From: Clerk & Responsible Finance Officer <clerk@boltonbybowland-gisburnforest-sawley-pc.org.uk>
Sent: 03 March 2026 19:45
To: Planning; Emily Pickup
Subject: 3/2026/0090 Riverside Lodge, Sawley

Bolton by Bowland Gisburn Forest & Sawley Parish Council has no objections to the above application. However, we would wish the comments below to be taken into consideration.

PROPOSED REAR ELEVATION (4)

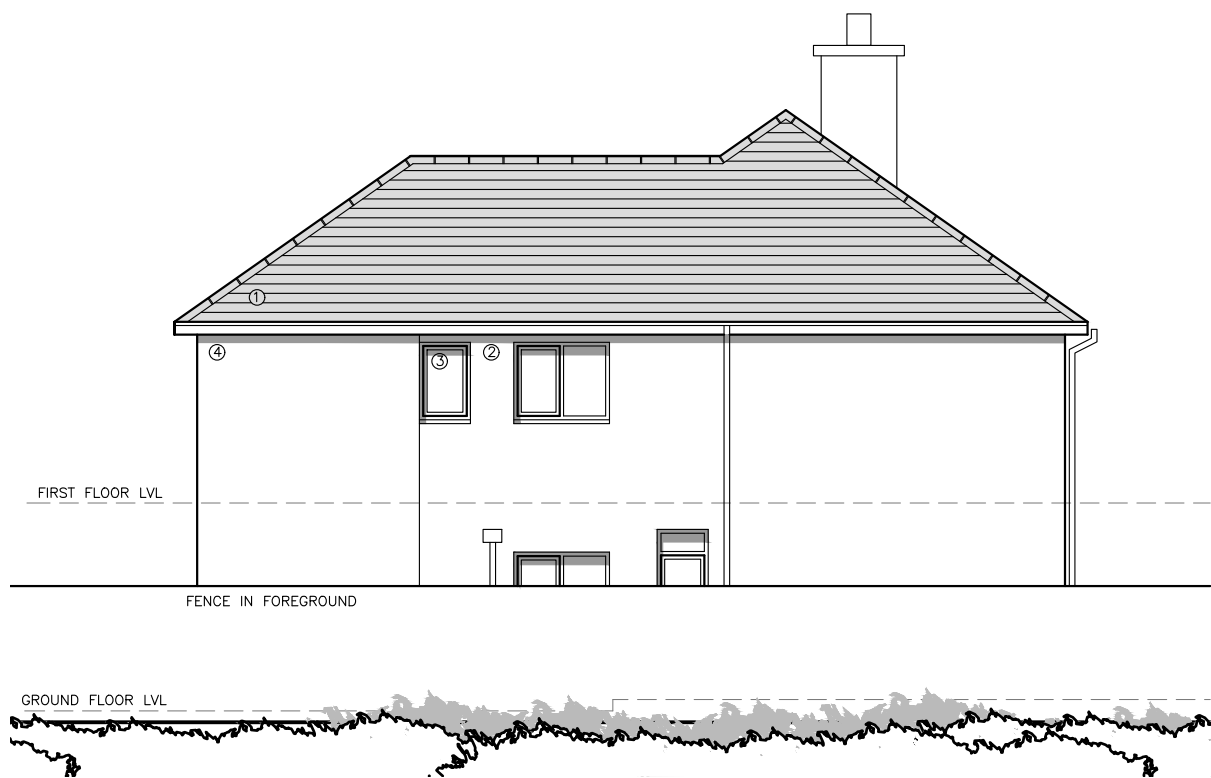
The Parish Council has no reservations regarding the actual building work, although four sets of patio doors in a row looks excessive. However, although it is hardly mentioned in the application, it would seem that the elevation looking over the river, which currently consists of brickwork/sand/cement, is to be replaced by sand/cement. It must be questioned whether a fully rendered finish will enhance the building. The existing brickwork gives it a warmth and would seem to be consistent with neighbouring properties.

Whilst not actively opposing the application please can the Planning Department carefully consider the proposed finish and also consider any conservation matters which apply to the property.
